Re: Permit # 2205-178
Simpson Residence Remodel
6454 E Mecer Way
Mercer Island, WA 98040

Subj.: Post Permit Revision Letter

A1.1

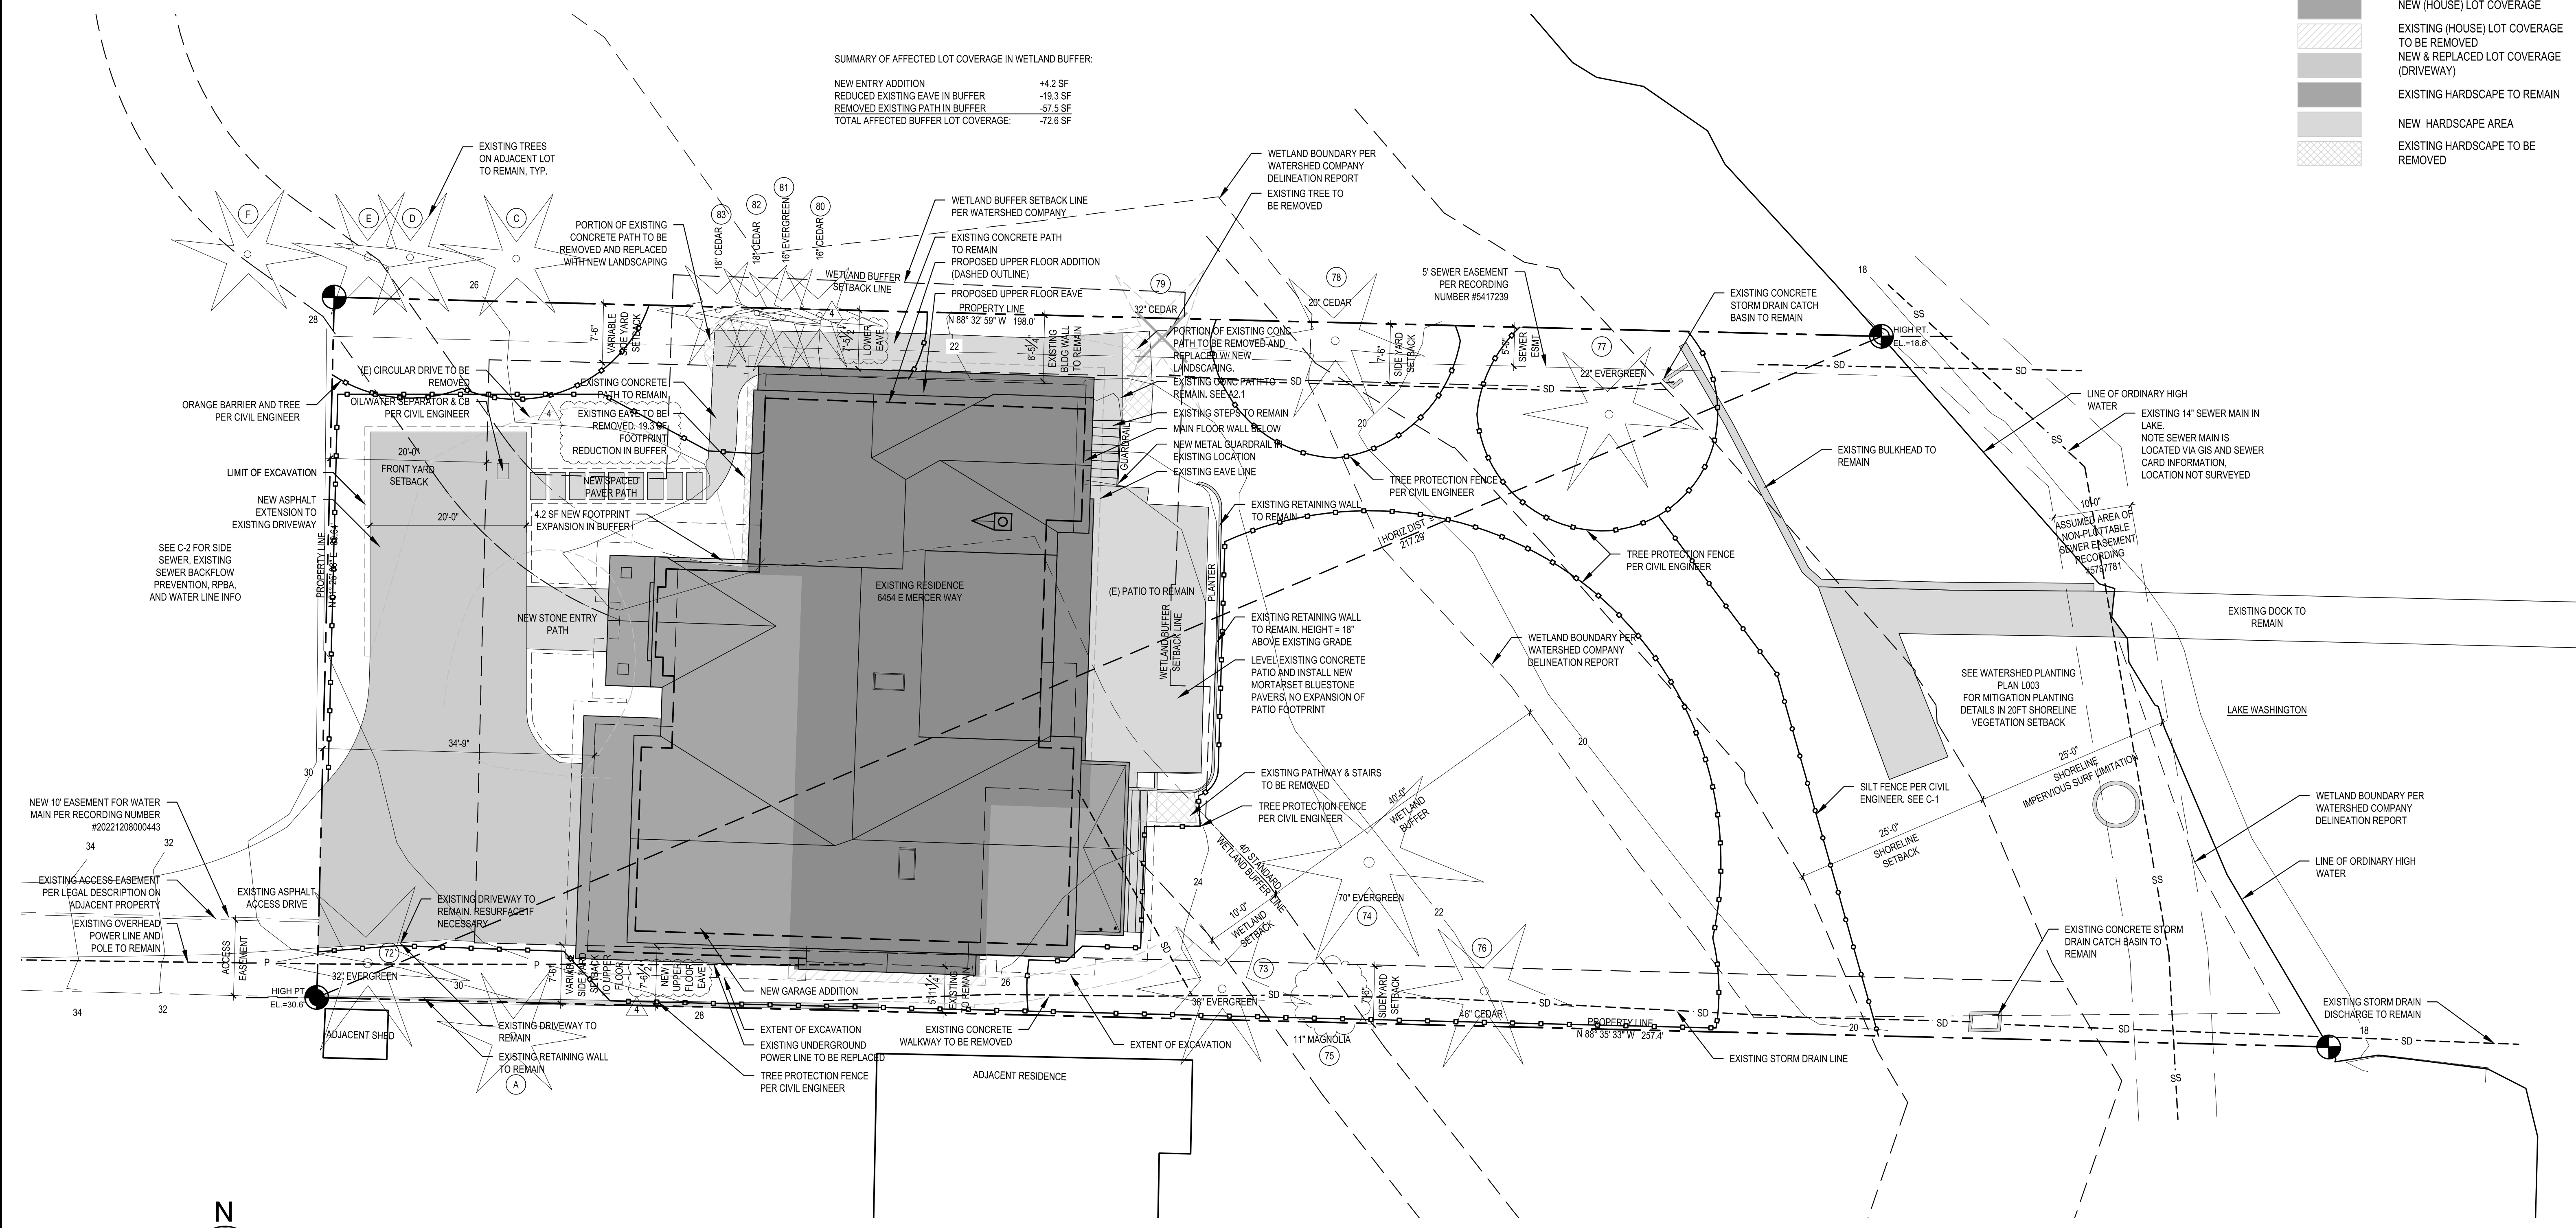
The new revised project essentially expands the upper floor over the existing main floor on the north side of the lot. No changes to the approved footprint of the house are being proposed other than some reductions in eave now that we can cut back the existing eave in the buffer.
